## **DEPARTMENT OF PUBLIC WORKS**

### **MEMORANDUM**

SUBJECT: Public Works Planning Review of Final Plat LPF-19-0001 Revision 2 (Evergreen Ridge P.U.D. – Rockberry Loop Plat)

Below are the Public Works Planning comments for the review of LPF 19-0001 Revision 2:

DWN BY	DATE	JOB NO.
D.L.P./G.W.	04/2019	16078
CHKD BY	SCALE	SHEET
D.L.P.	1" = 100'	2 OF 6

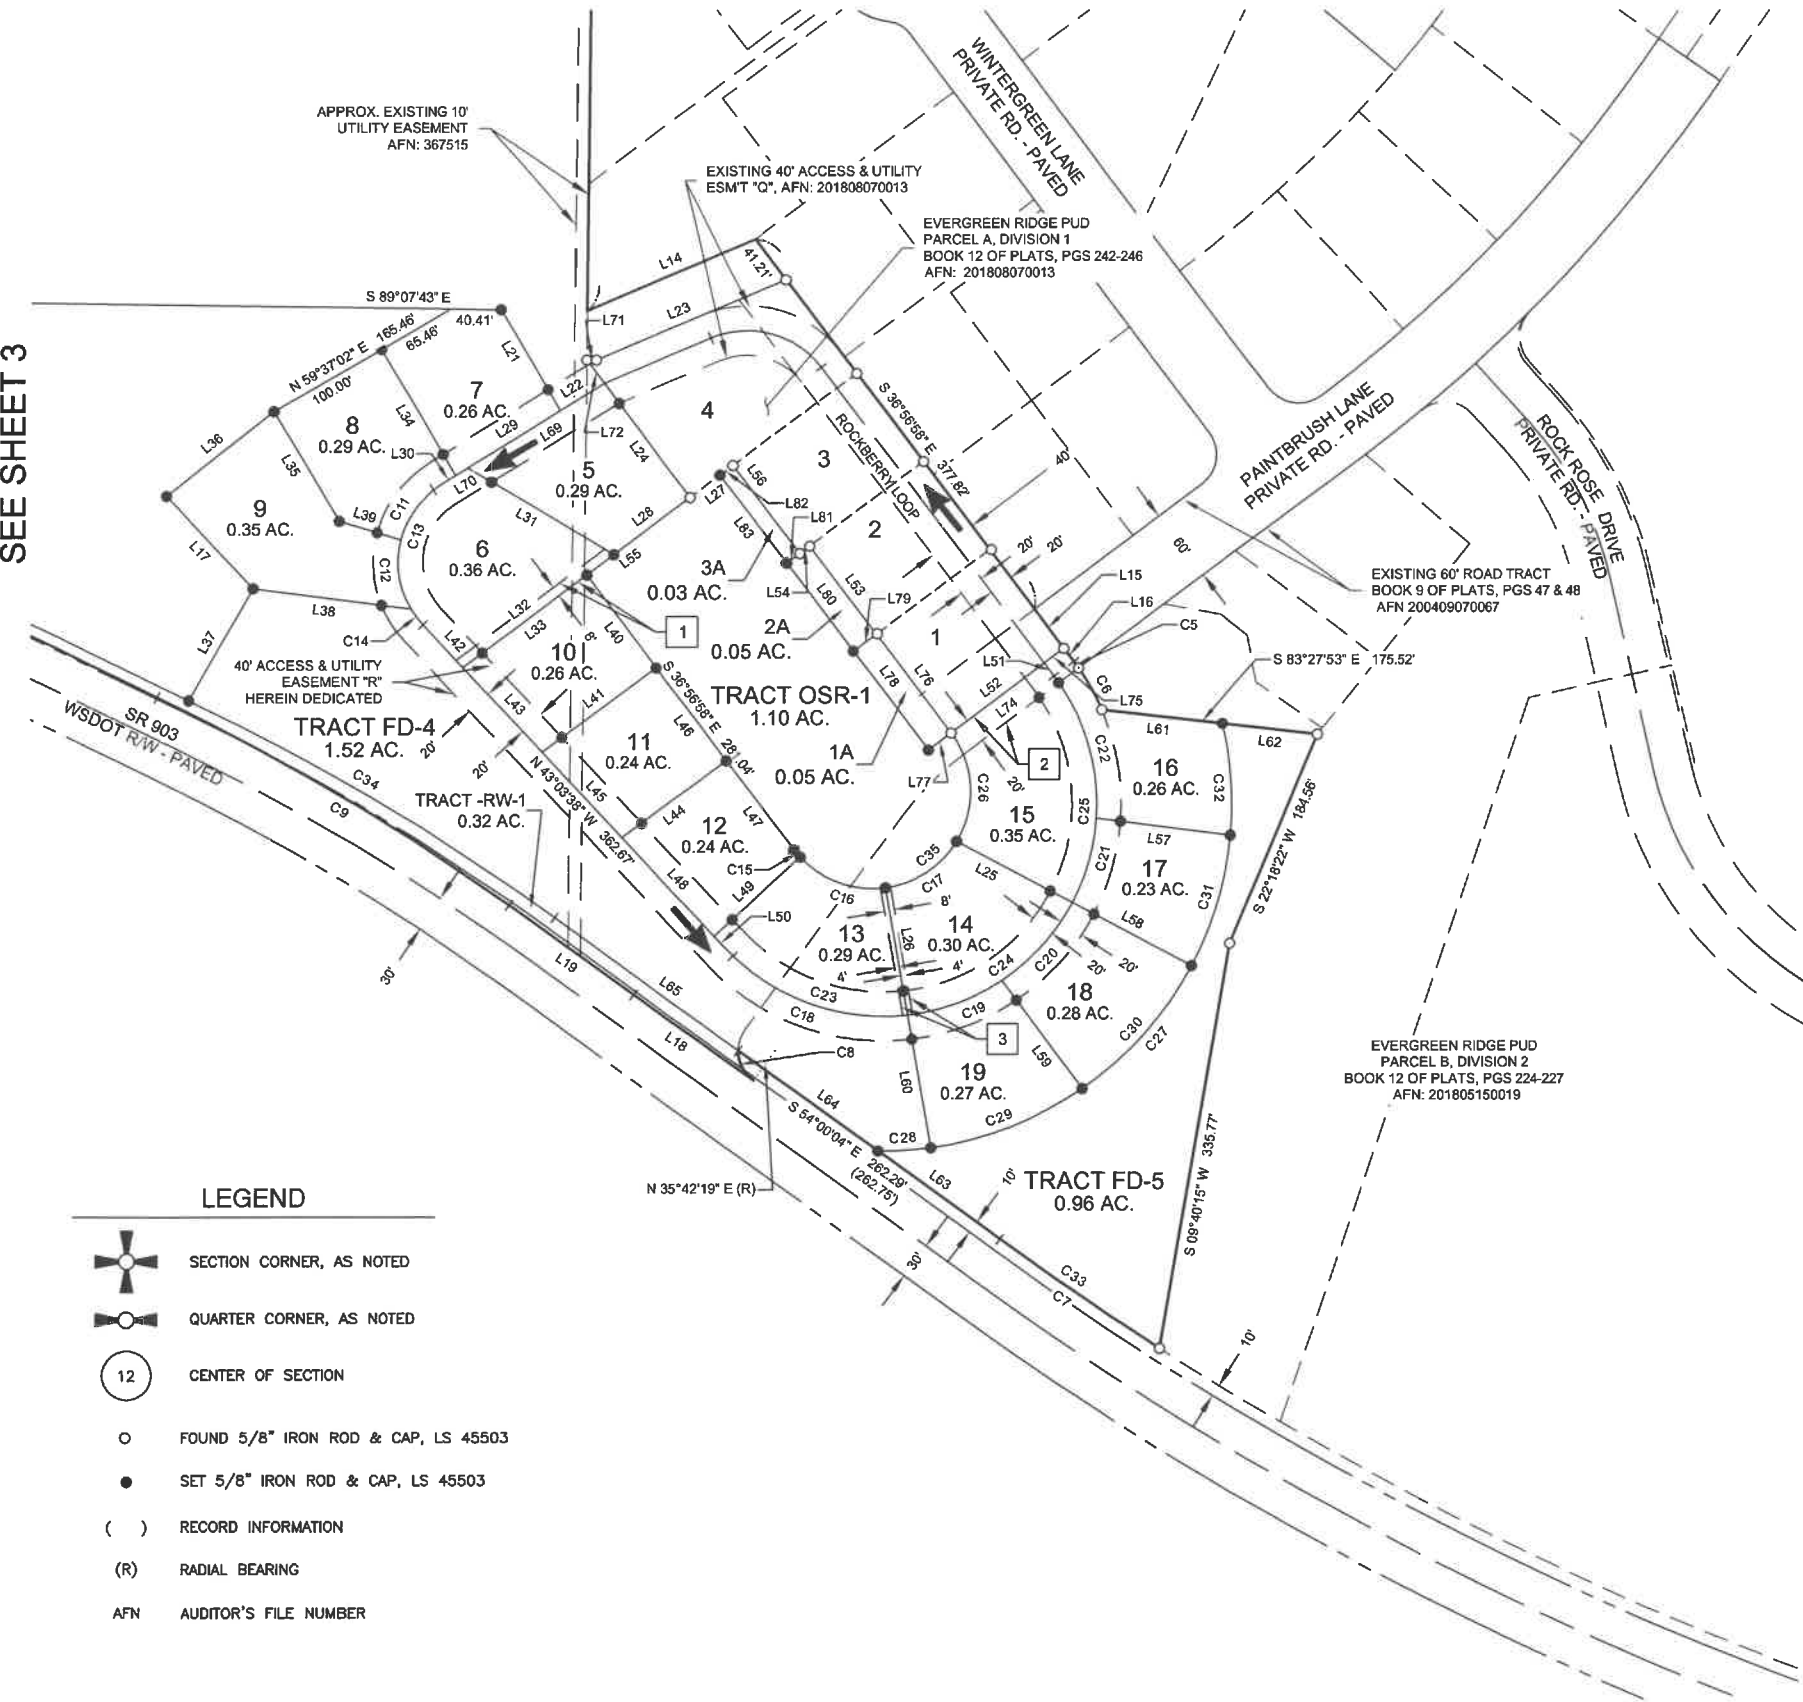
1. Provide access easements to Lot 20 and Tract FD-3, as they do not have direct access onto SR 903.
2. All existing structures need to be shown on the face of the plat.
3. Turning radius needs to be shown for the intersection of Paintbrush Lane and Rockberry Loop right of way.
4. Approved stormwater plans required prior to final approval.
